**RE: Sydney Grammar School, Weigall Sports Complex: State Significant Development (SSD-10421):  
Response to Condition B1**

This letter on the Sydney Grammar School Weigall Sports Complex (SSD-10421) is written on behalf of Sydney Grammar School. It responds to SSD-10421 Condition B1 which states:

- B1. Prior to the issue of any construction certificate, the design of Building 1 (Sports Complex building) must be amended and revised architectural plans and documentation demonstrating compliance with the condition must be submitted to, and approved by, the Planning Secretary. The revised design must modify the design of that part of Building 1 located directly opposite 8 Vialoux Avenue (i.e. the building component east of the Building 1 stair core/Multipurpose Hall 4 and including the area above the program pool) to reduce the view loss impact experienced by the north facing living rooms within apartments 1, 5, 8 and 12 at 8 Vialoux Avenue. The amendments to the design must comprise (unless otherwise agreed with the Planning Secretary) the following:

Drawing Title
**BUILDING 01
SPORTS FACILITIES BUILDING
GENERAL ARRANGEMENT PLAN
SECOND**

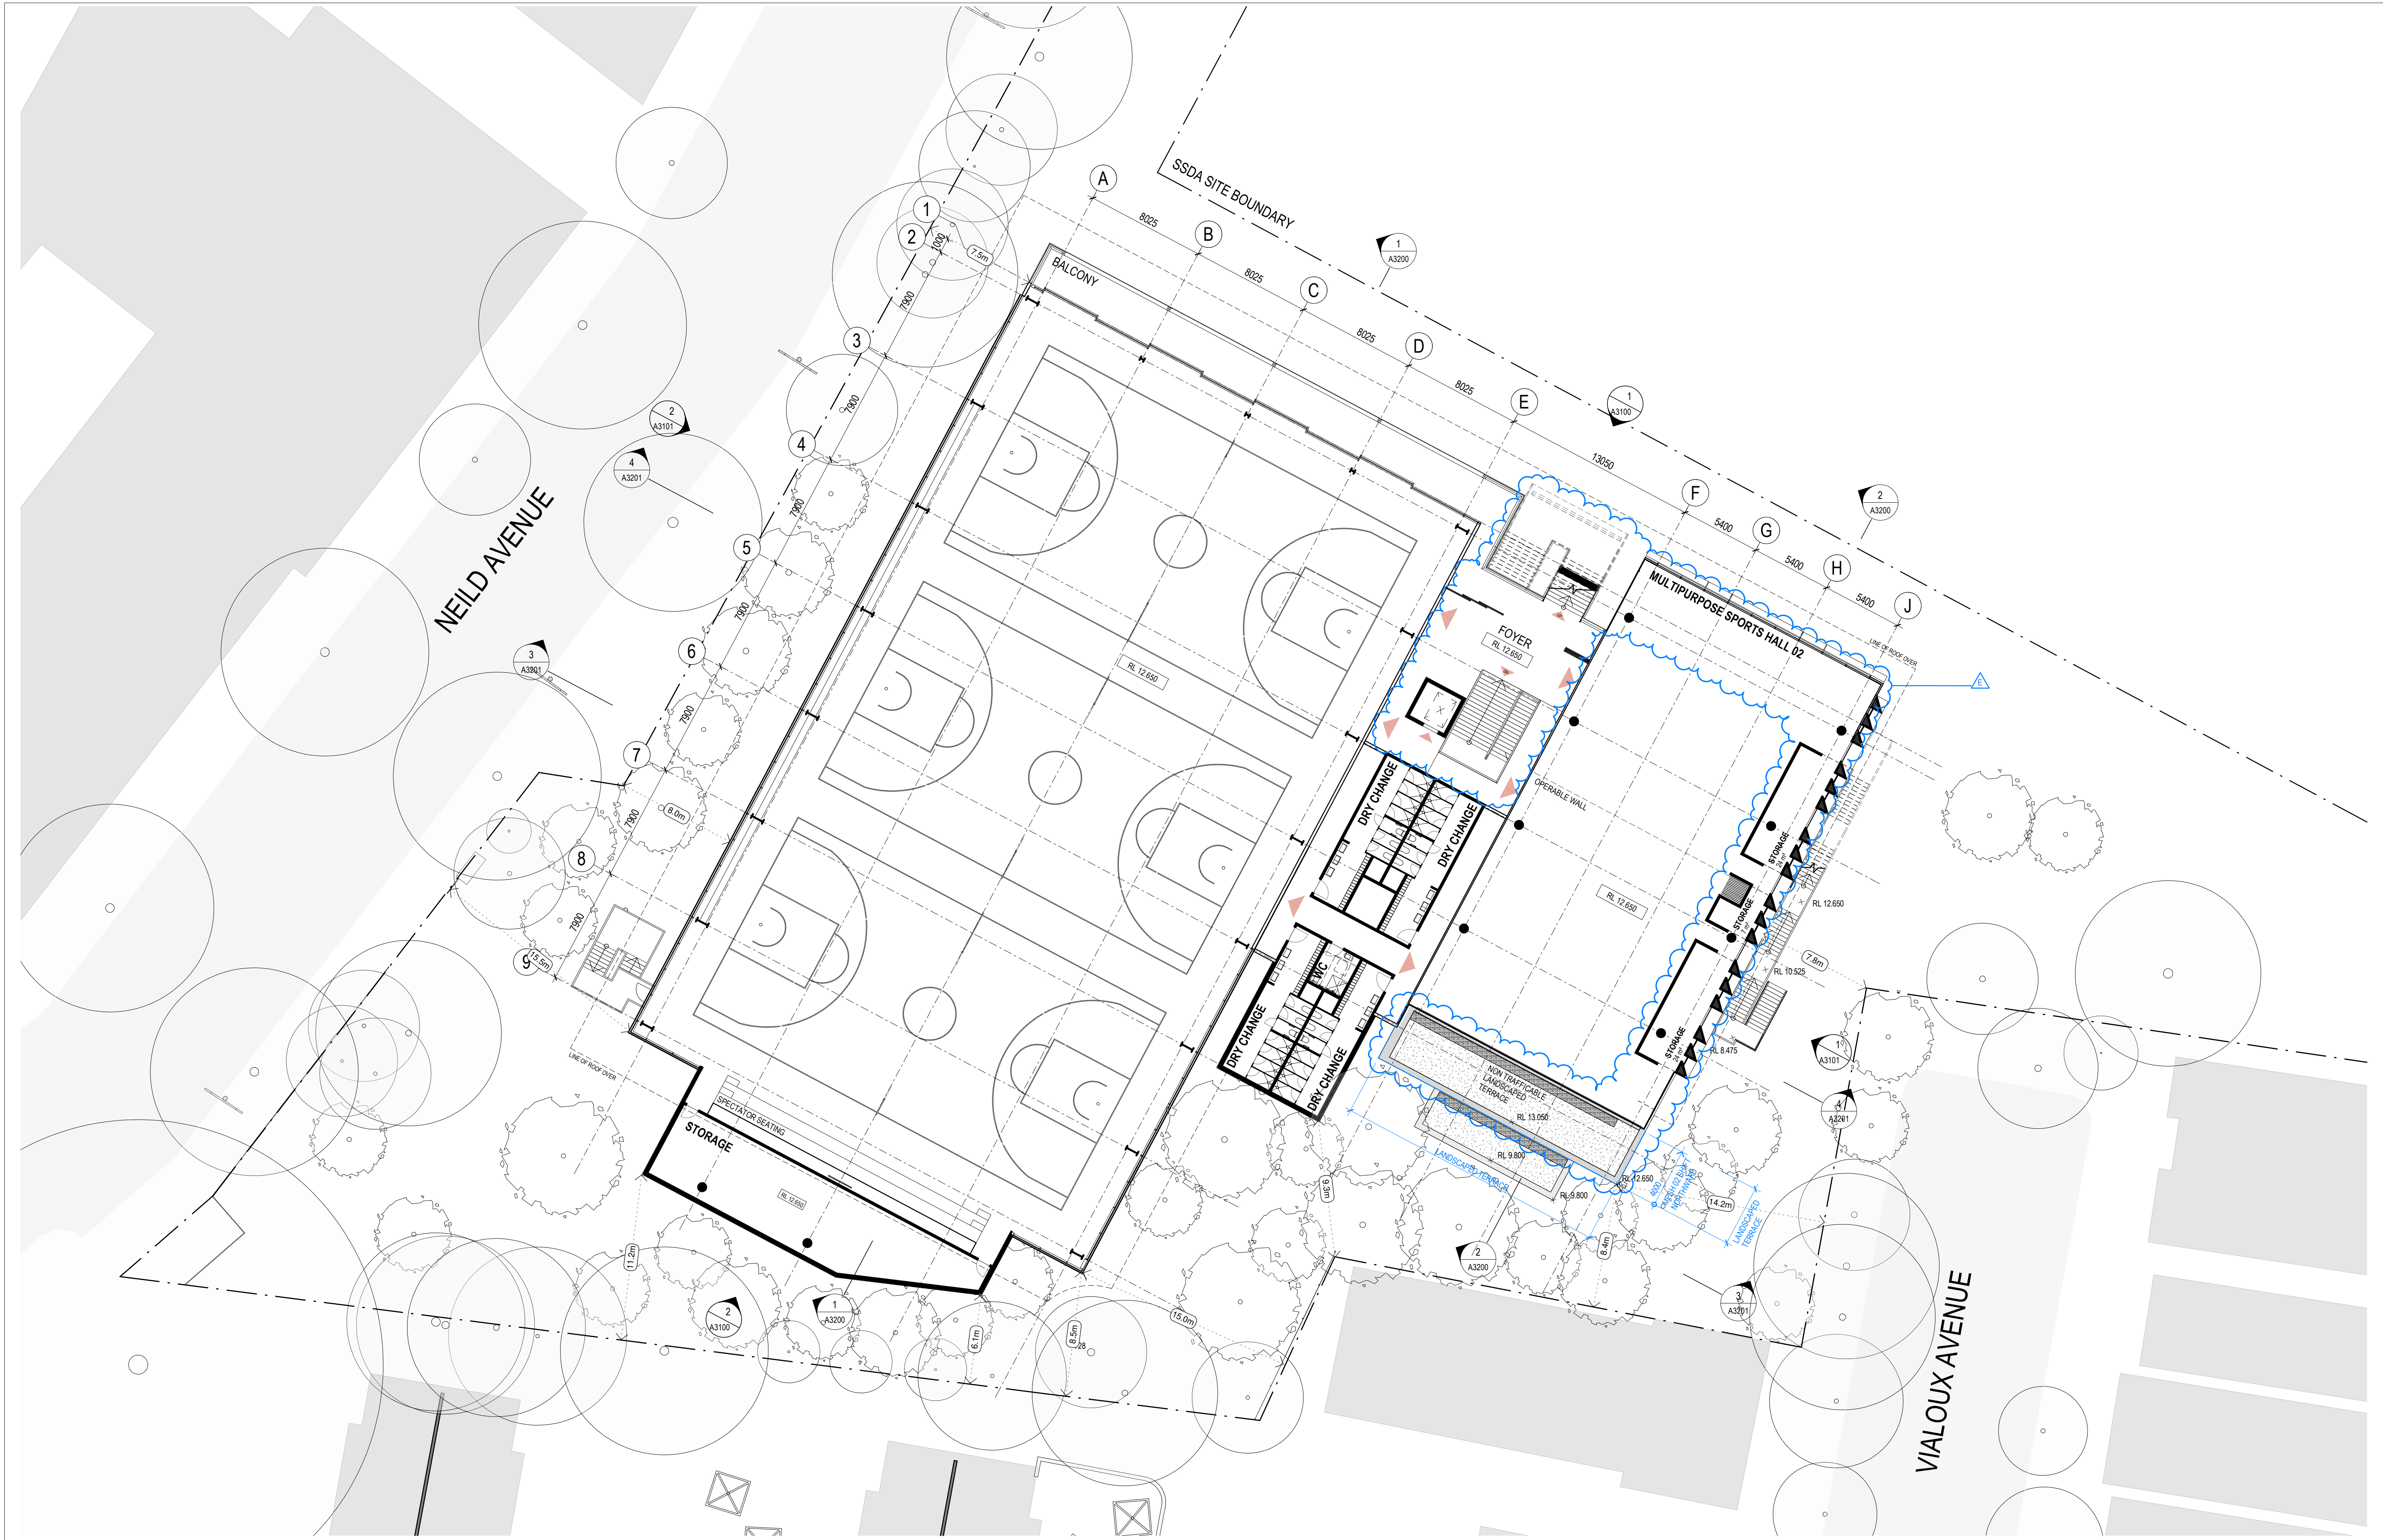
1. Level 1, Multipurpose Sports Hall 2 (see **Figure 1**):
  - Relocated **4m** northward to increase the southern boundary setback
  - Non-trafficable landscaped terrace to the new setback area
2. Level 2, Multipurpose Sports Hall 3 (see **Figure 1**):
  - Relocated **3m** northward to increase the southern boundary setback
  - Non-trafficable landscaped terrace to the new setback area

Drawing Title
**BUILDING 01
SPORTS FACILITIES BUILDING
GENERAL ARRANGEMENT PLAN
ROOF**

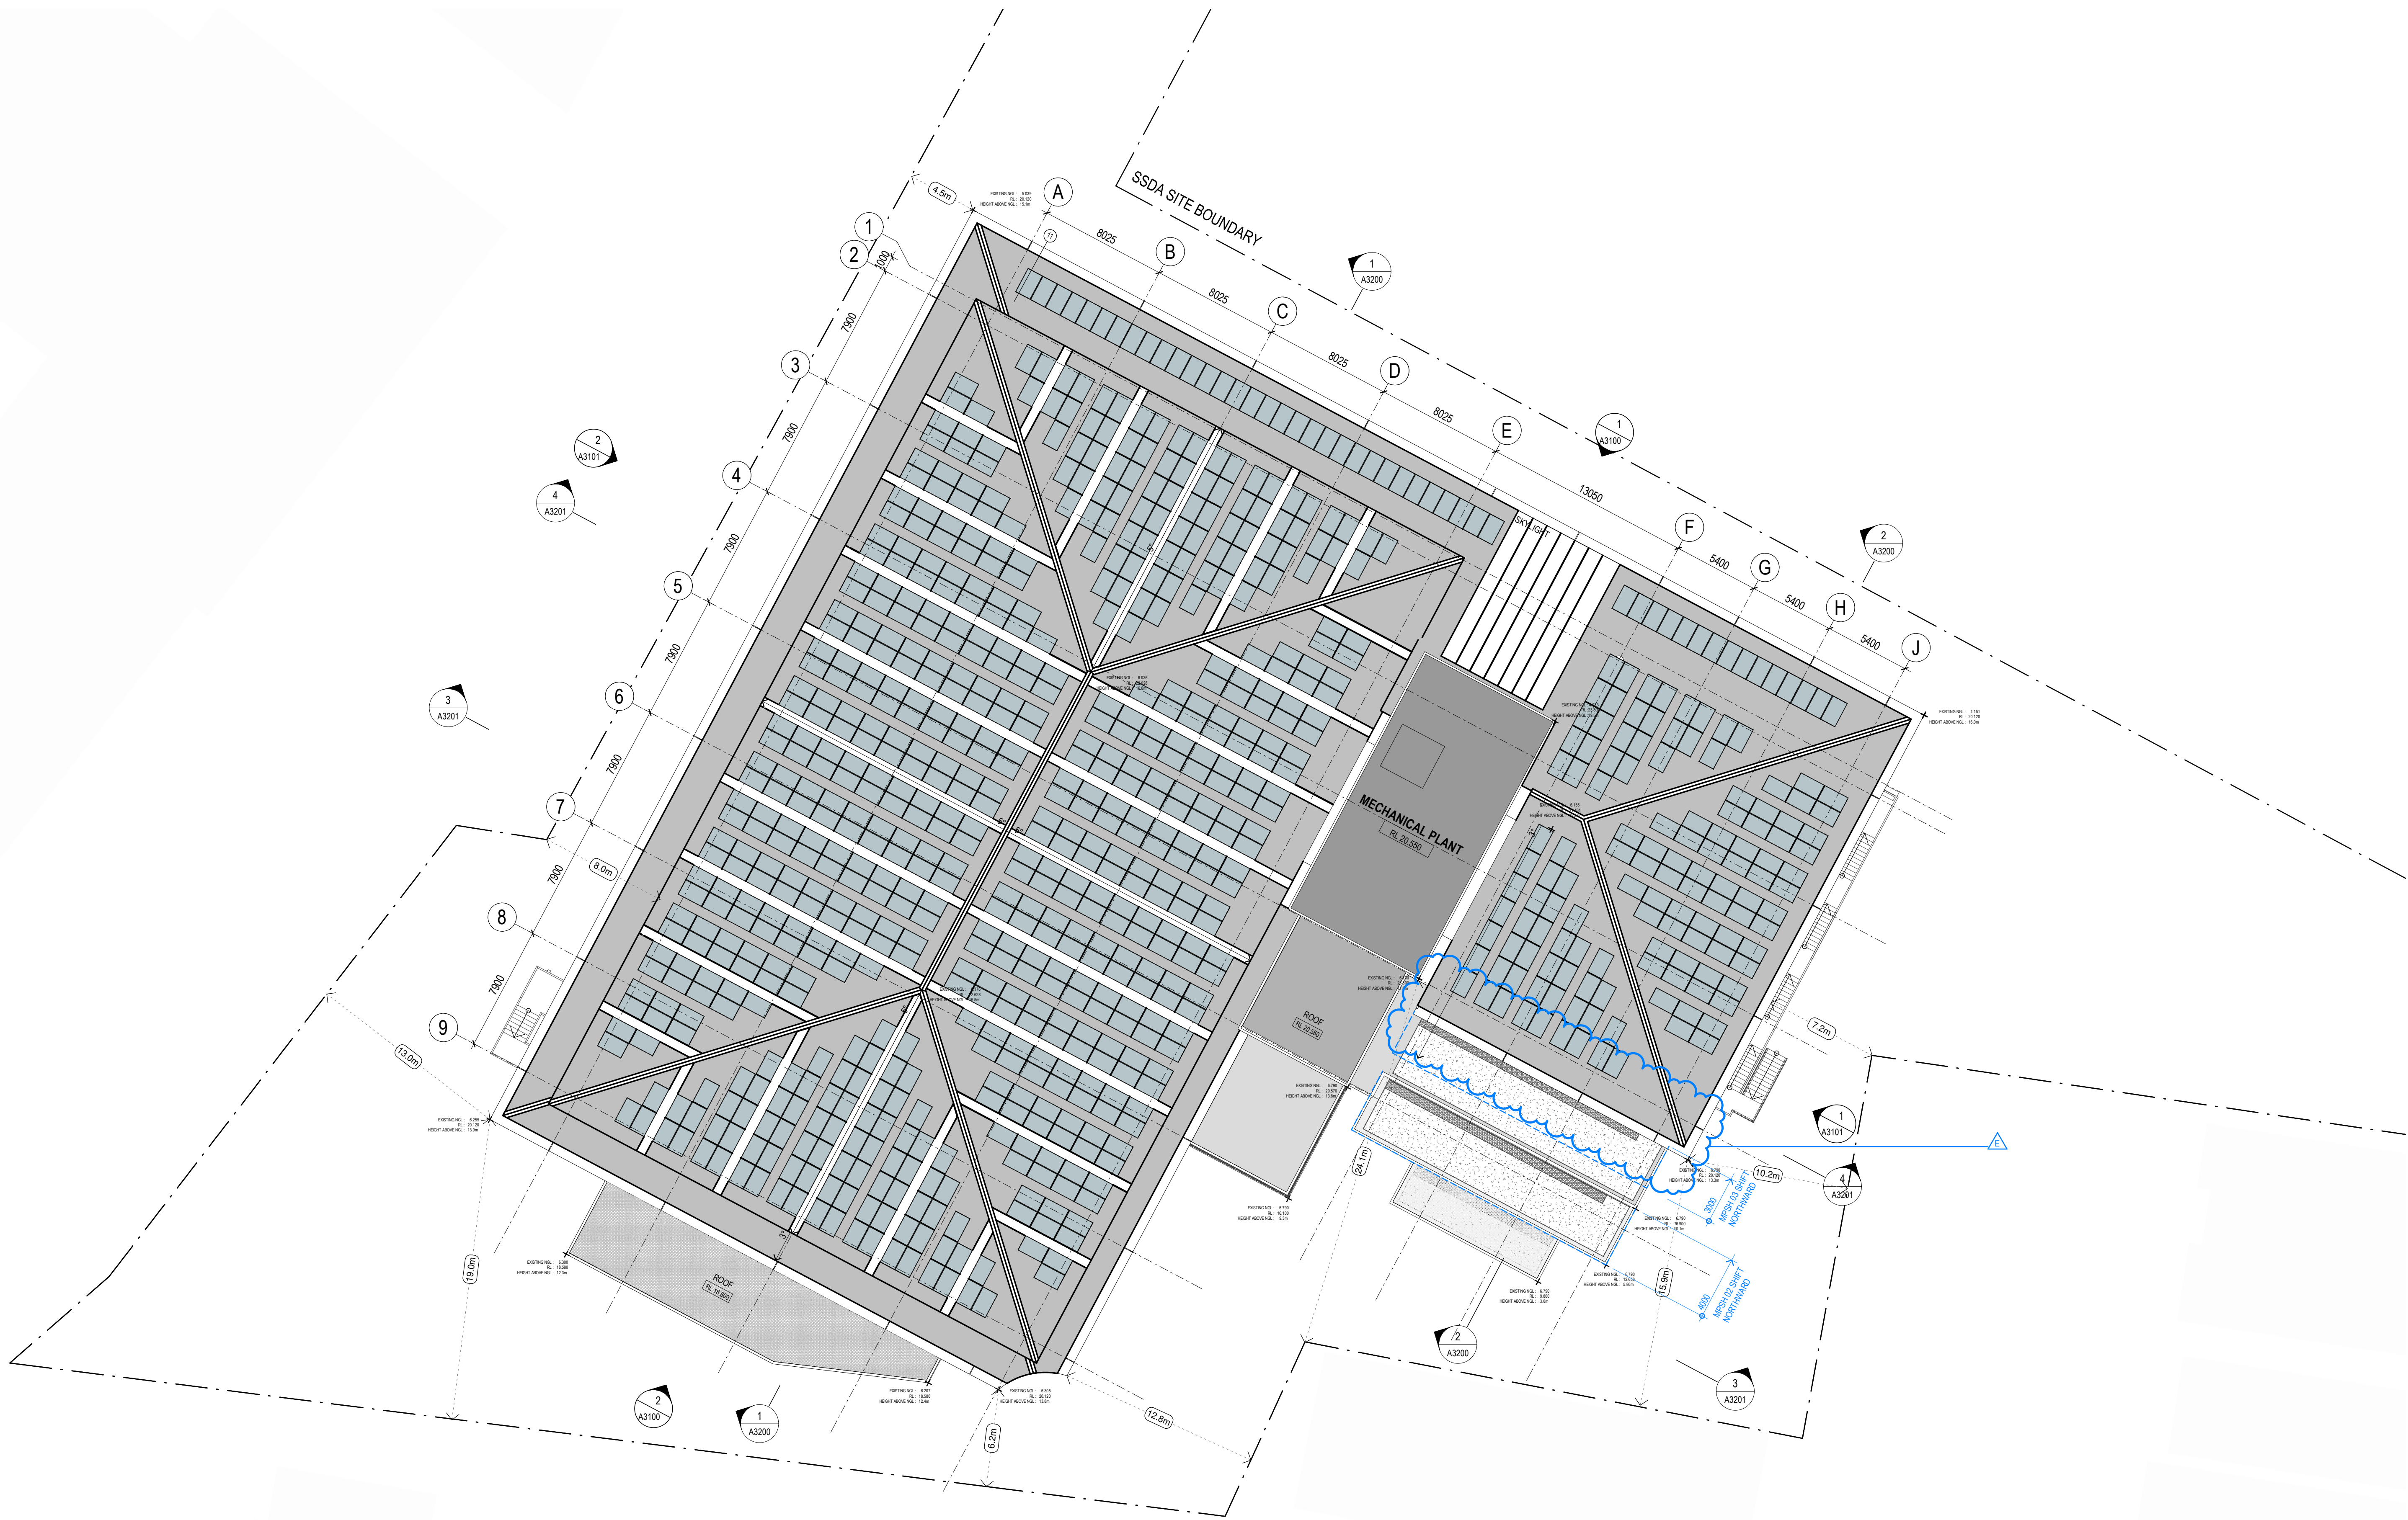
4. Roof Plan is reduced to reflect the Level 1 and 2 southern boundary setback (Design Amendments 1, 2 and 3). The northern section of the Roof Plan does not change
